EPC STORMWATER REVIEW COMMENTS  
IN ORANGE BOXES WITH BLACK TEXT

# WOODMOOR WSD

## WELL NO. 22

#### SWMP, GRADING AND EROSION CONTROL PLAN

SHEET NO.
G0.1

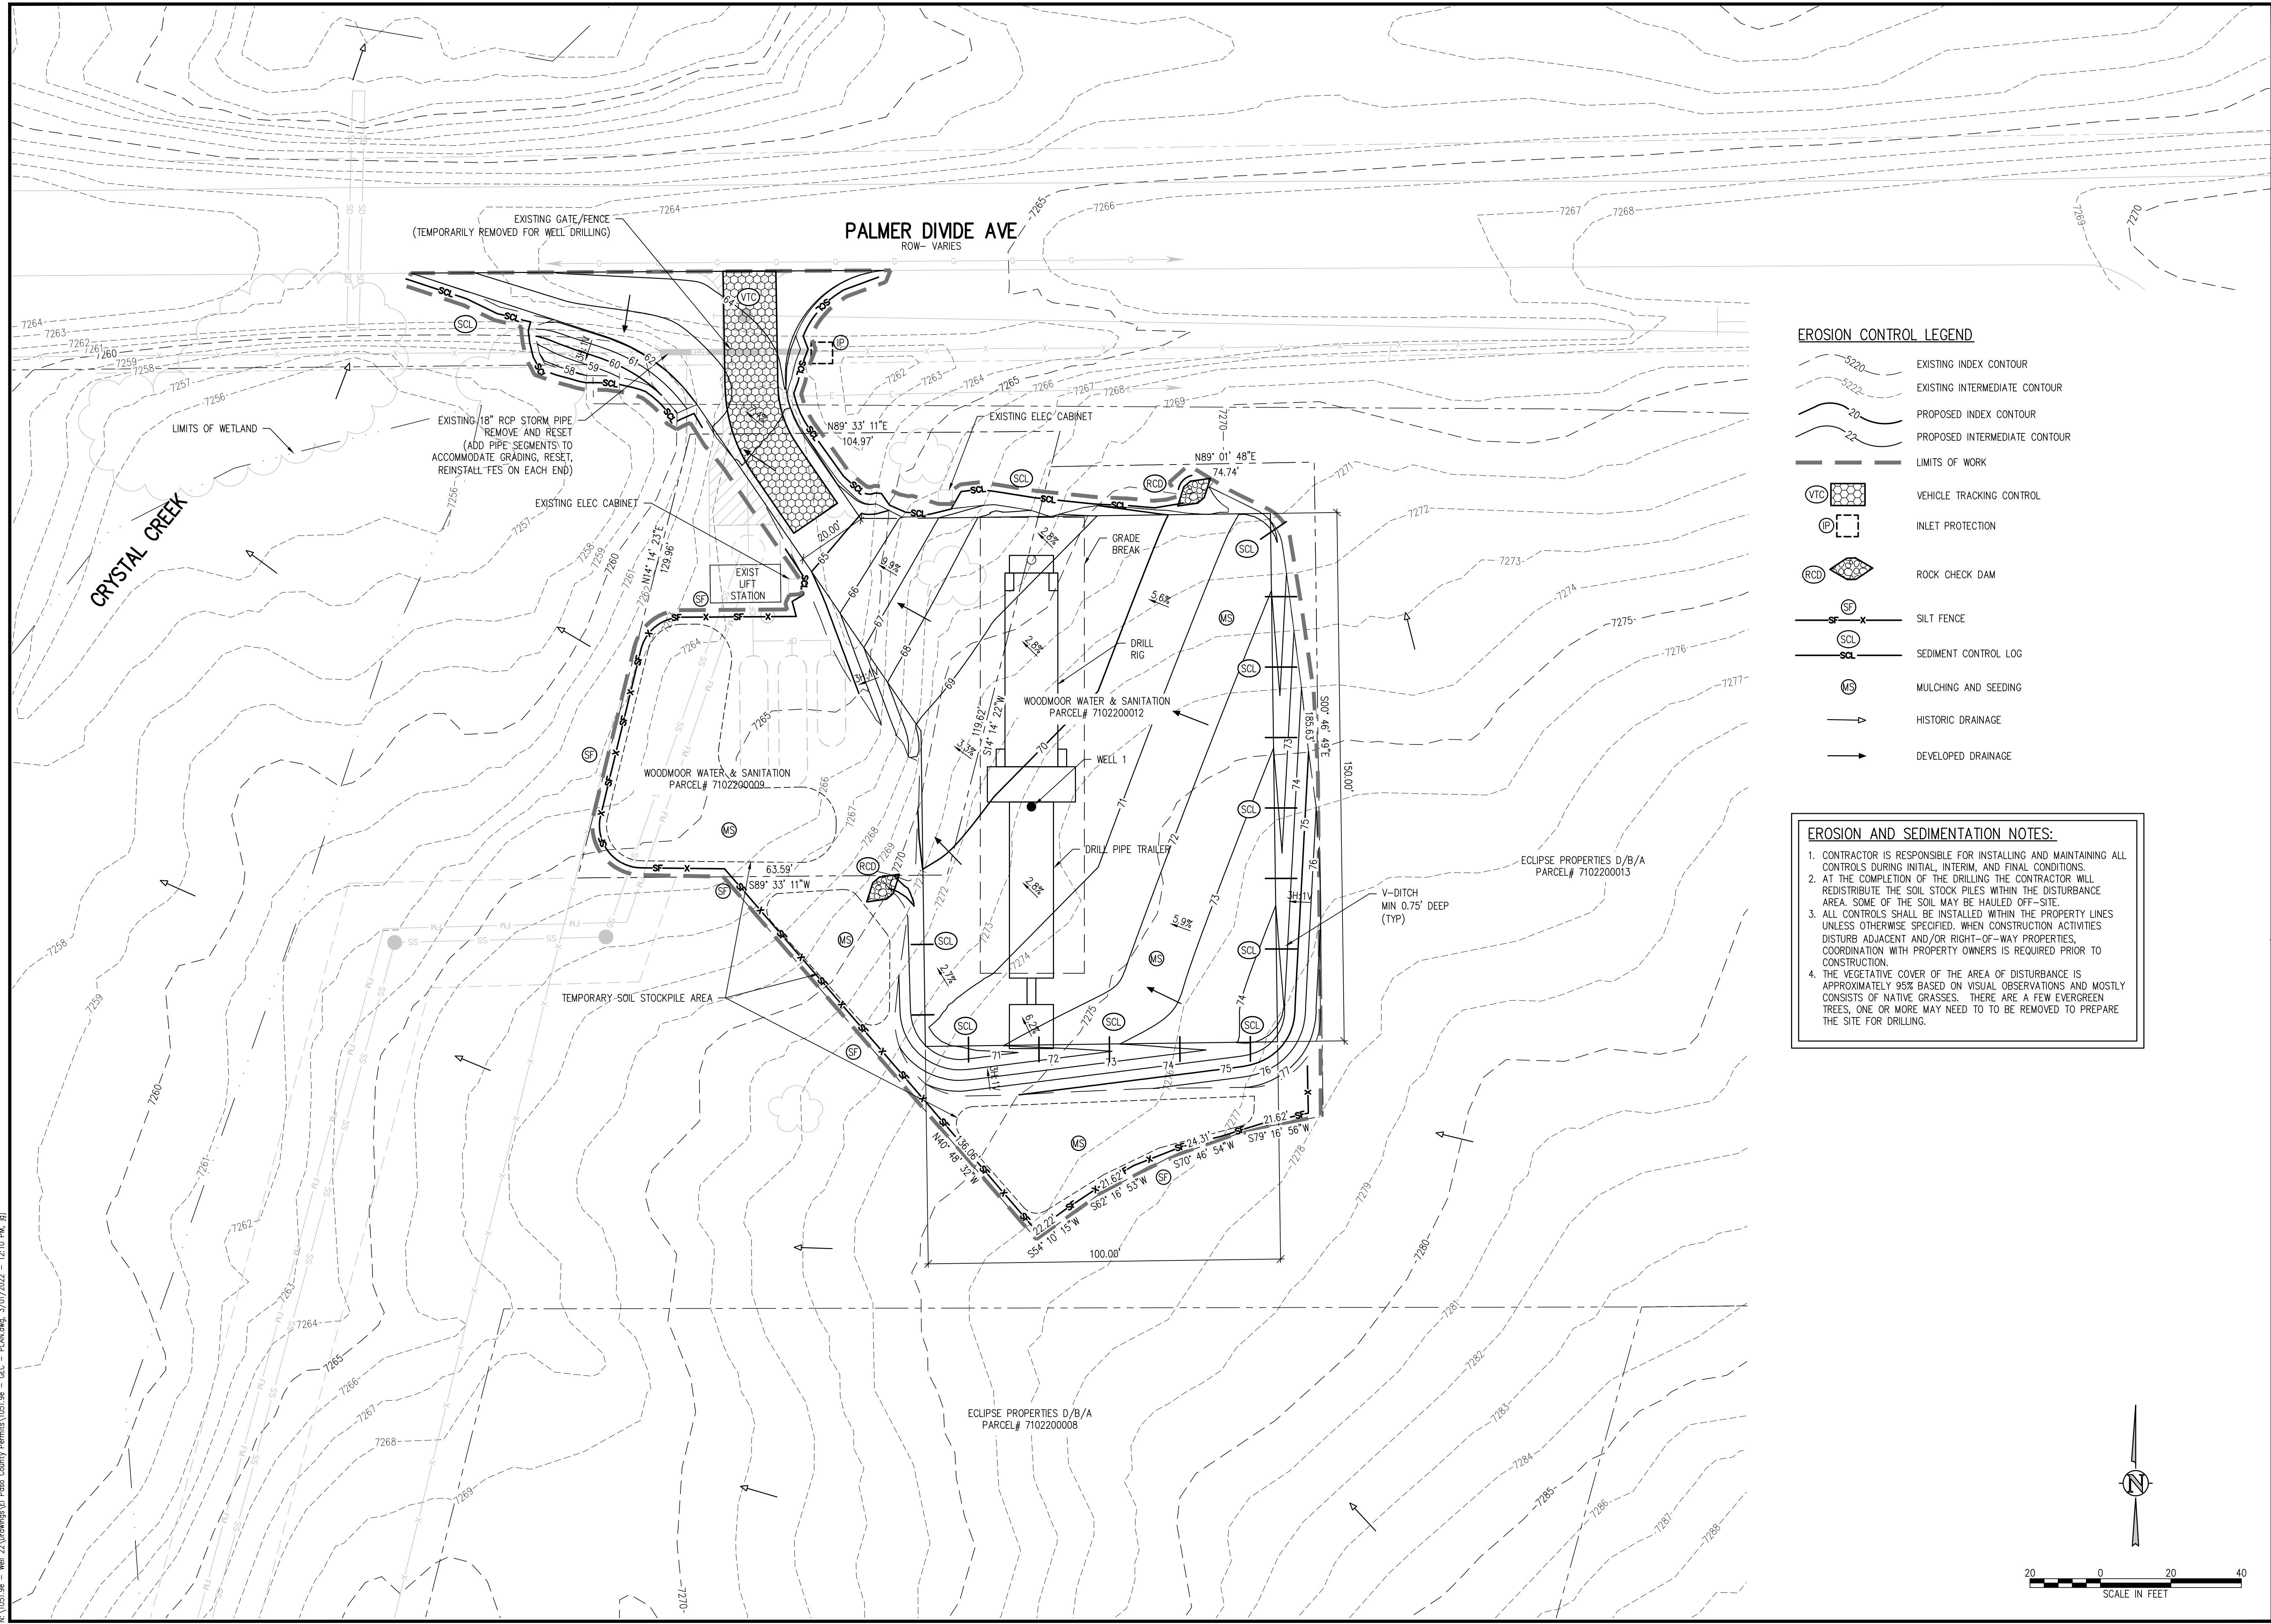
Checklist Item "o" - If applicable, call out as offsite grading, to be approved by EPC. If any of this work will take place in the EPC ROW, note that contractor to obtain an "EPC Work Within the ROW" Permit

Checklist Items H and M. If "limits of disturbance" and "construction boundary" are the same, change to "limits of construction/disturbance" or otherwise show as separate line types for each on the legend and figure.

Checklist Item "p" - delineate or notate generally where cut/fill areas are located.
